ATKINS

S/AR/2009/289

Application for Outline Planning Permission for conversion of existing house into 2 no. flats & erection of 2 no. new dwellings
7 Nelson Road Aldwick Bognor Regis PO21 2RY
BR/289/09

Site Block Plan @ 1:500

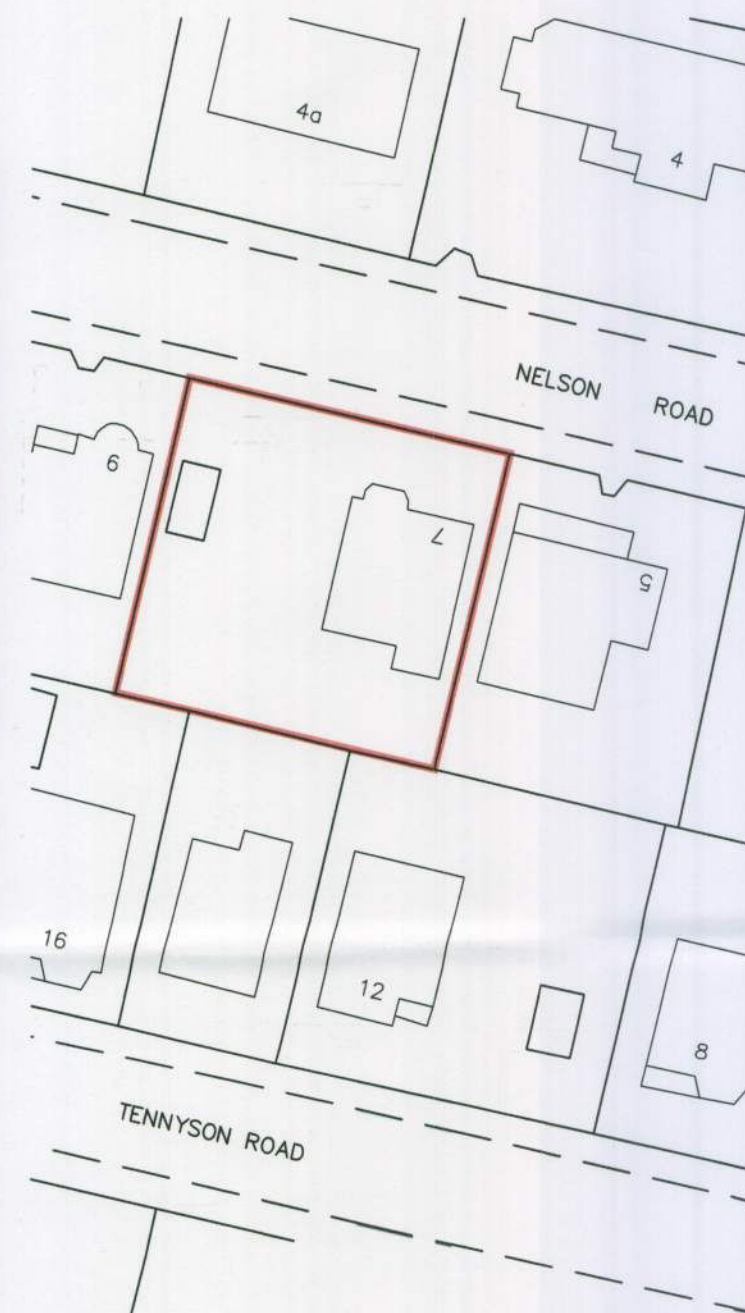
Please find attached a plan of the sewer records showing the approximate position of a public sewer crossing the site. The exact position of the public sewers must be determined on site by the applicant before the layout of the proposed development is finalised.

From our initial assessment of the existing apparatus it appears that there is limited opportunity to divert existing drainage apparatus, and therefore Southern Water objects to the proposed development. If planning permission were to be granted, Southern Water (as the statutory sewerage undertaker) would request that the Council (as the Building Control Authority) refuse Building Regulations approval on the grounds that building over the public sewer cannot be permitted.

In order to progress the proposed development on the site, the layout must be amended.

The 225mm diameter sewer requires a clearance of 3.0 metres either side of the sewer to protect it from construction works and allow for future access for maintenance.

No development or new tree planting should be located within 3.0 metres either side of the centreline of the public sewer.

No new soakaways should be located within 5m of a public sewer.
